Subject: RE: Planning notification for application reference: 22/00499/DISC - OBJECTION

Bourton Footpath 8 runs through this site. **I must object to this planning application the amended plan does not show the correct definitive line of the footpath.** But instead shows only the permissive route. The definitive line of the footpath is shown (roughly) by the red line on the plan below and on the map below

# SITE LAYOUT PLAN

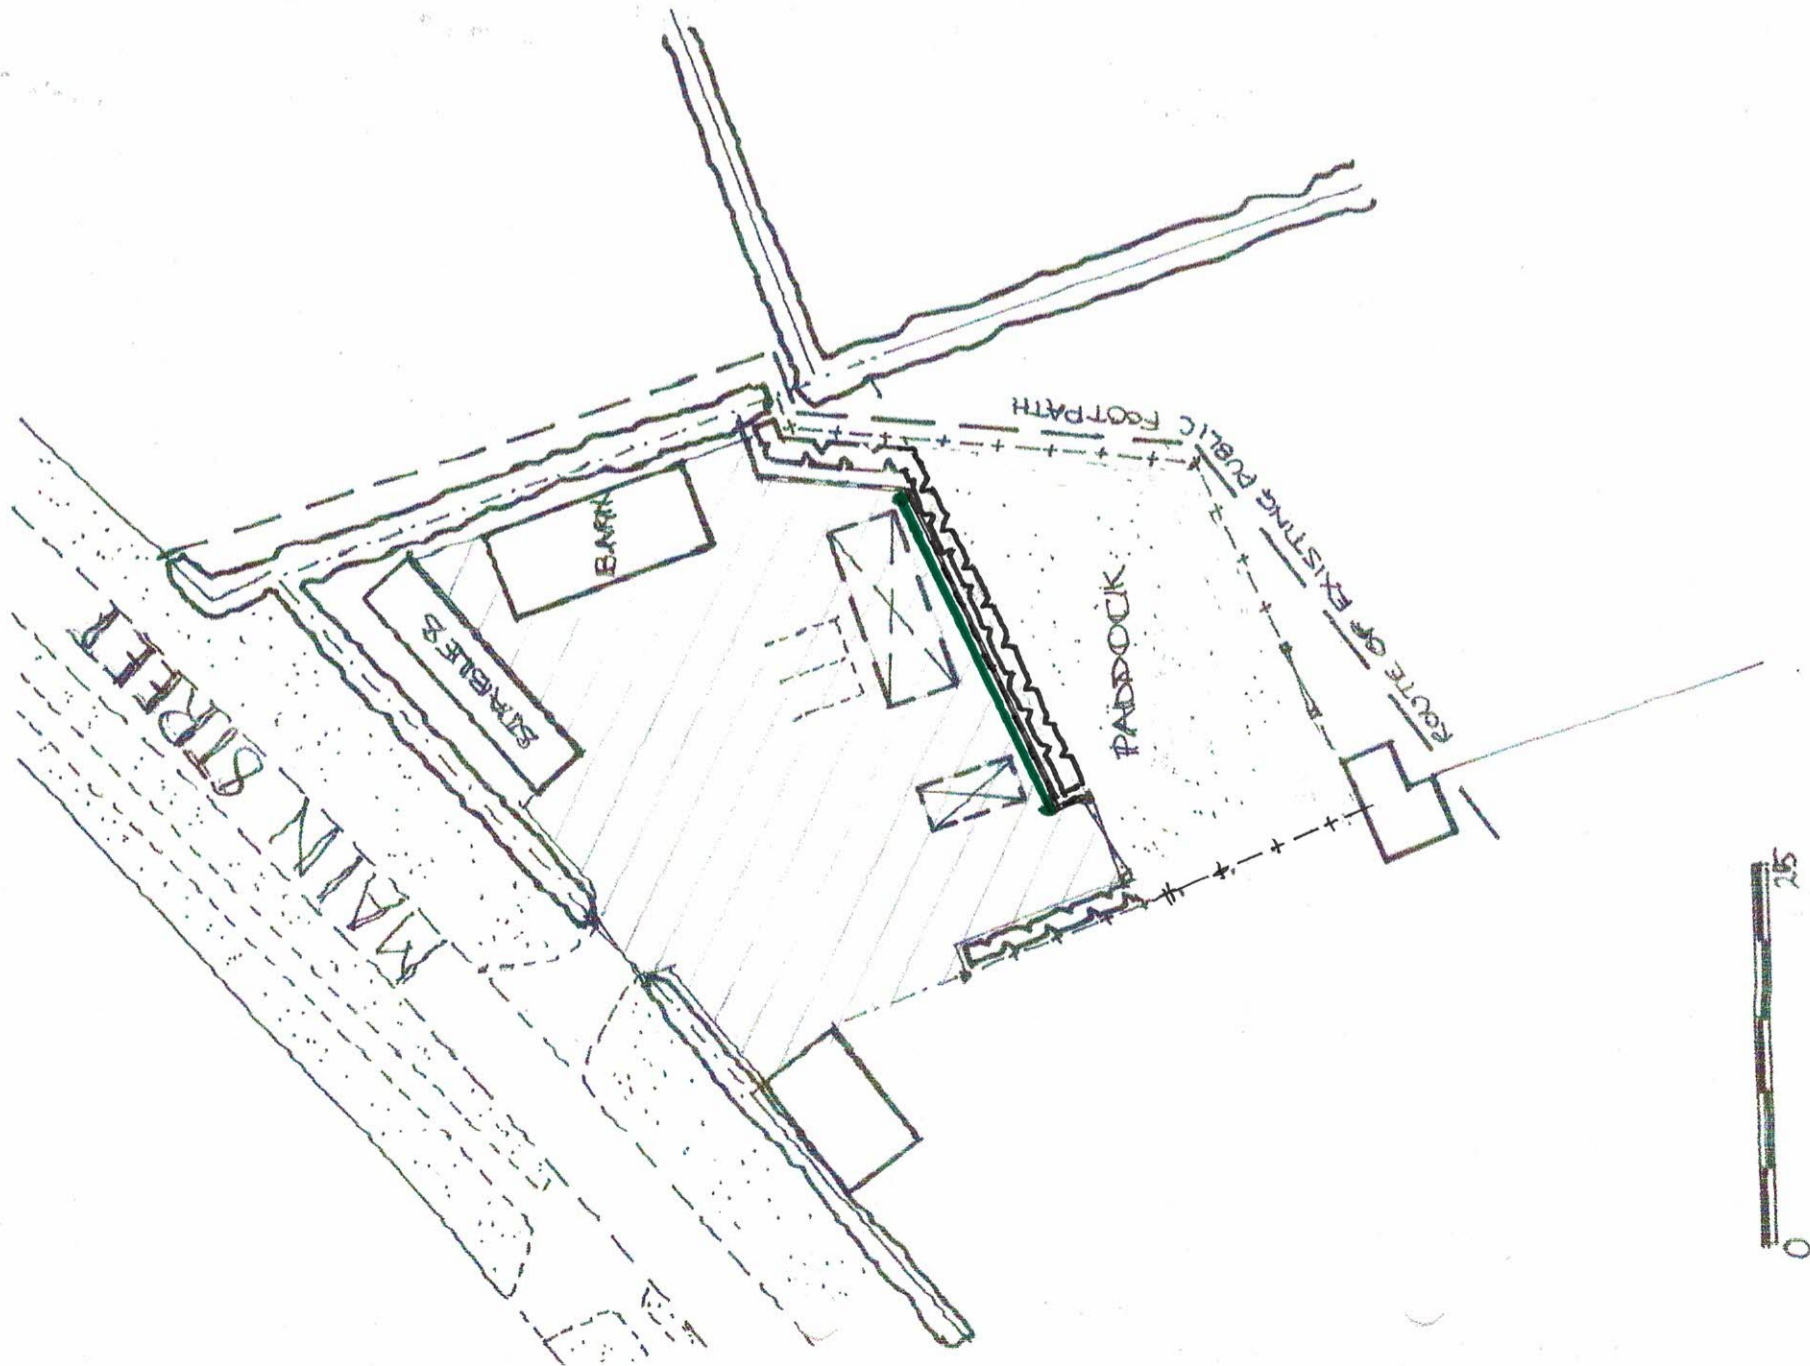
The proposed screen fence and tree/hedge planting is welcomed, as it is hoped this will separate the dogs on site from the footpath users. However, I believe the screen fence and planting on the amended proposal may obstruct the definitive line of the footpath (not shown on the plan), particularly the planting. Adjusting the layout of the planting and screen fence where the footpath enters the site would resolve this issue. A suggestion is marked on the plan below in green. A member of the Oxfordshire County Council's Countryside Access Team would be happy to meet on site to discuss the fence and planting arrangement.

It may be possible to legally divert the footpath, but this is a process separate to the planning application. Mr Doran should contact Oxfordshire County Council's Countryside access team via countryside@oxfordshire.gob.uk to get further details of this process.
